Portishead Branch Line (MetroWest Phase 1)

TR040011

8.13, Addendum to the Construction Traffic Management Plan

Date: September 2021

Figure 4-1: MetroWest Phase 1 Compounds – Portishead to Gordano

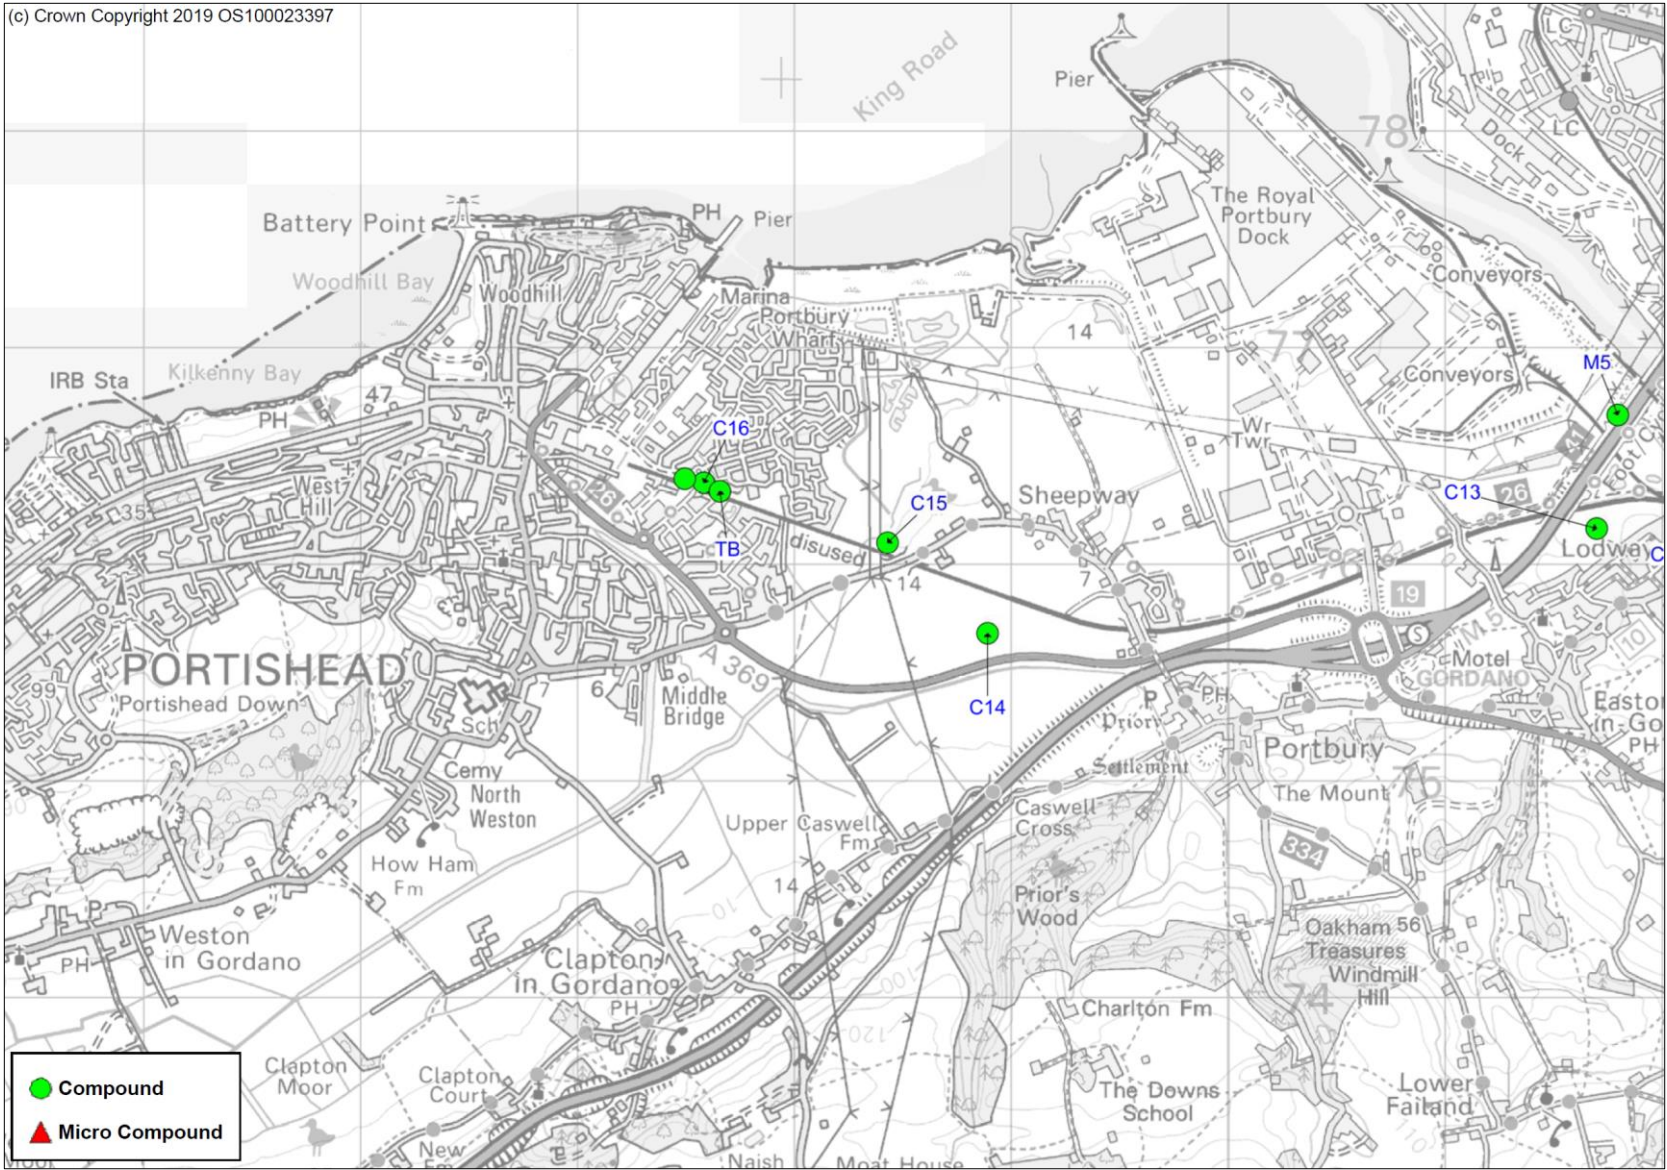
2.1.4 Table 4.1 is revised to remove reference to Trinity Primary School Bridge.

Ref	Name	Location	Main Purpose	Access
C16	Portishead Station	Portishead on the sites of new station car parks (both A on eastern side of the realigned Quays Avenue and B to the west of Quays Avenue)	For construction of Portishead Station and Trinity bridge. There is potential to use as a laydown area for Trinity bridge, subject to space availability	Access off Portbury Hundred, Wyndham Way and Quays Avenue. The majority of the deliveries will be on standard HGVs
ТВ	Trinity bridge <u>I</u> Lay down		As required combined with use of Portishead station compound	As Portishead station compound
